Wenona School - SSD6952 (MOD2)

I refer to our meeting on Friday 26 October 2018 that was also attended by your Andrew Beattie and Kate Tudehope of Ethos Urban, to discuss SSD6952 (MOD2). This letter responds to your request at the meeting for further information.

## APPENDIX D

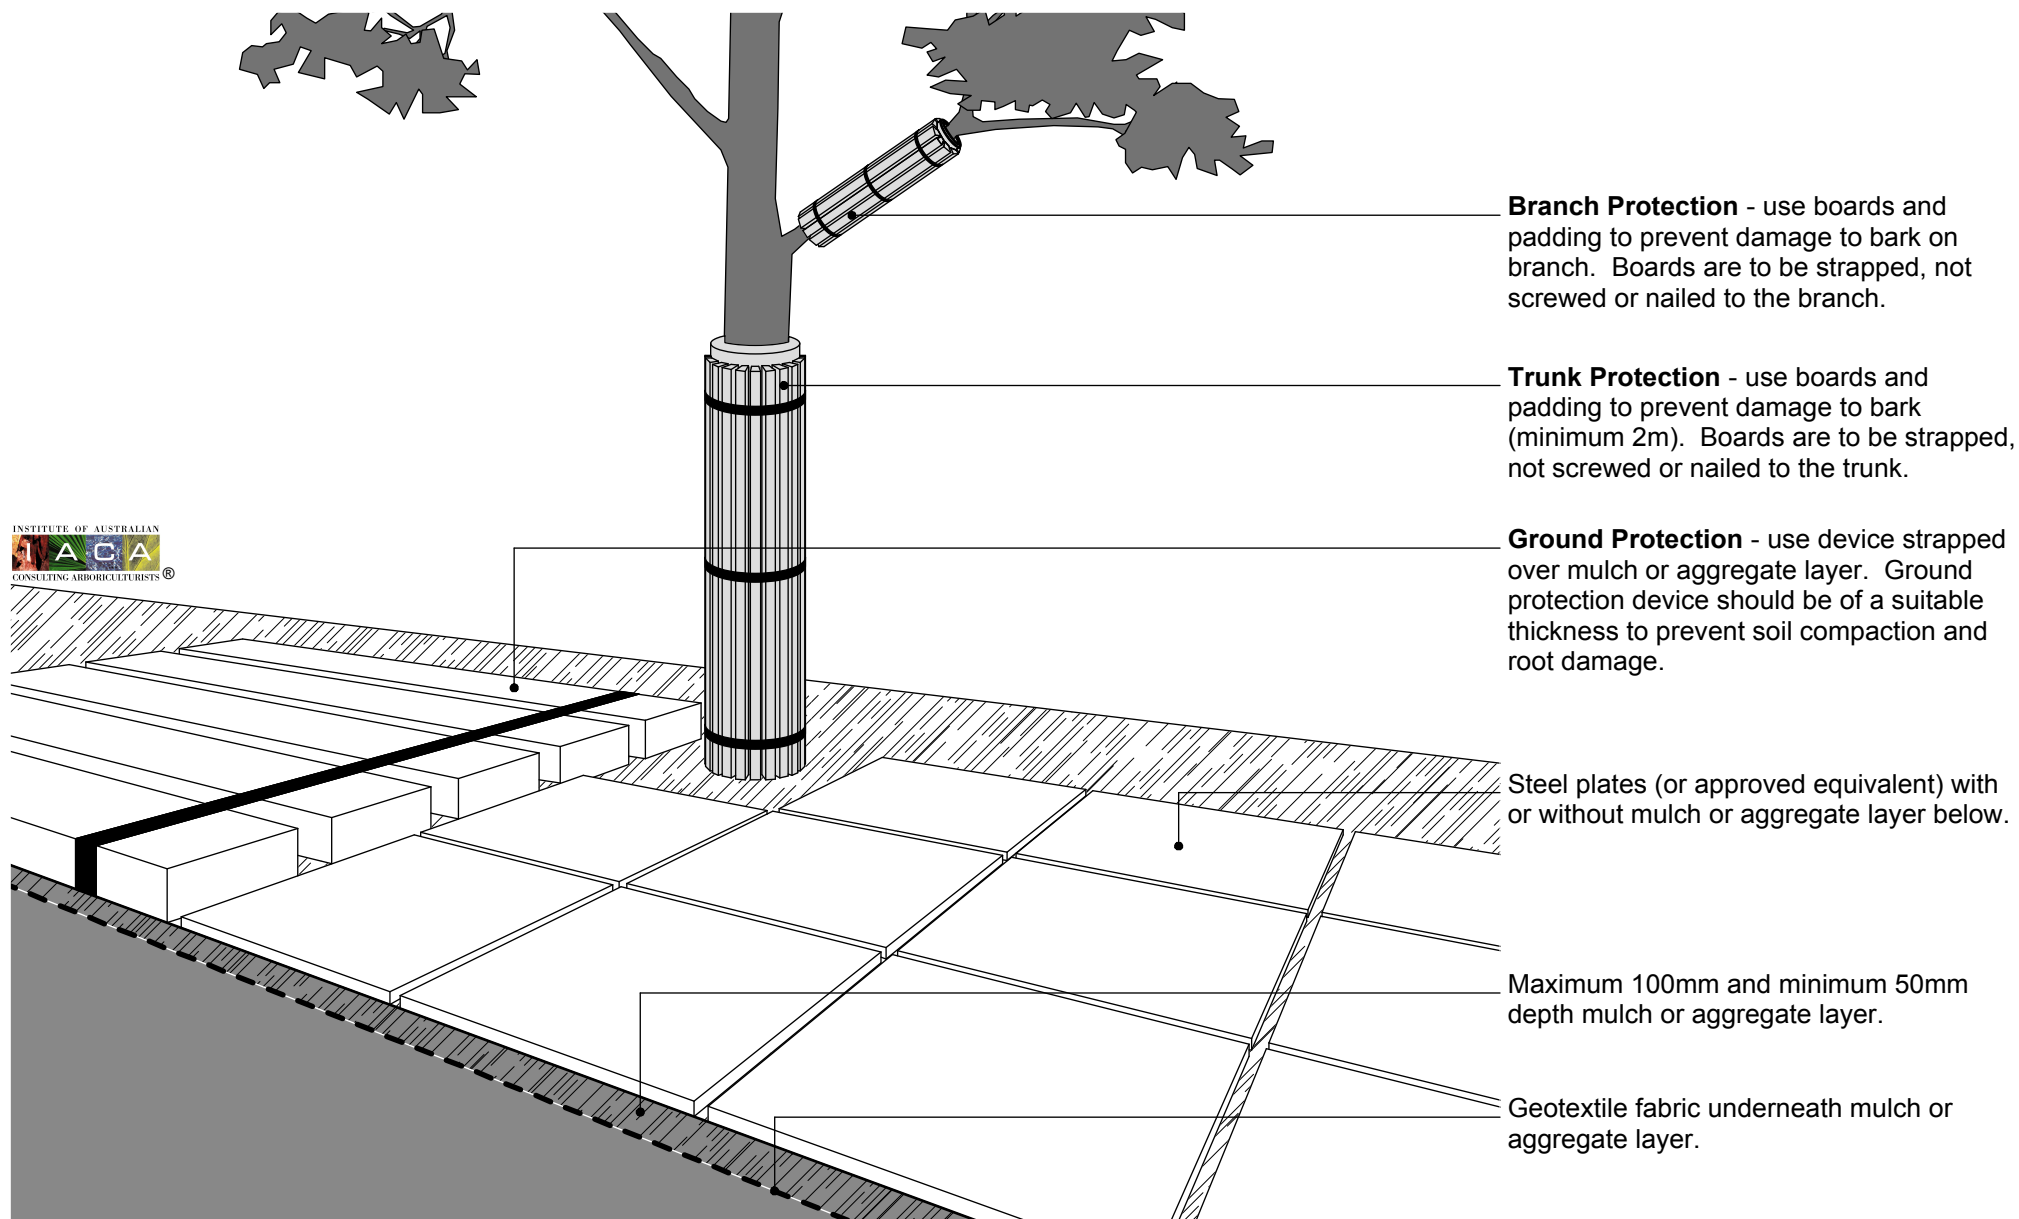
Ausgrid has advised that it is not willing to install the substation if the substation easement would create an incursion into the SRZ. Accordingly, the easement must be at least 3.4 metres from the outside of the trunk of the subject tree whereas at present as shown in the drawing in **Appendix D** it is 300mm from the outside face of the tree.

A dimensioned diagram that clearly shows the position of the proposed substation easement in relation to the subject tree.

This is contained in **Appendix D**.
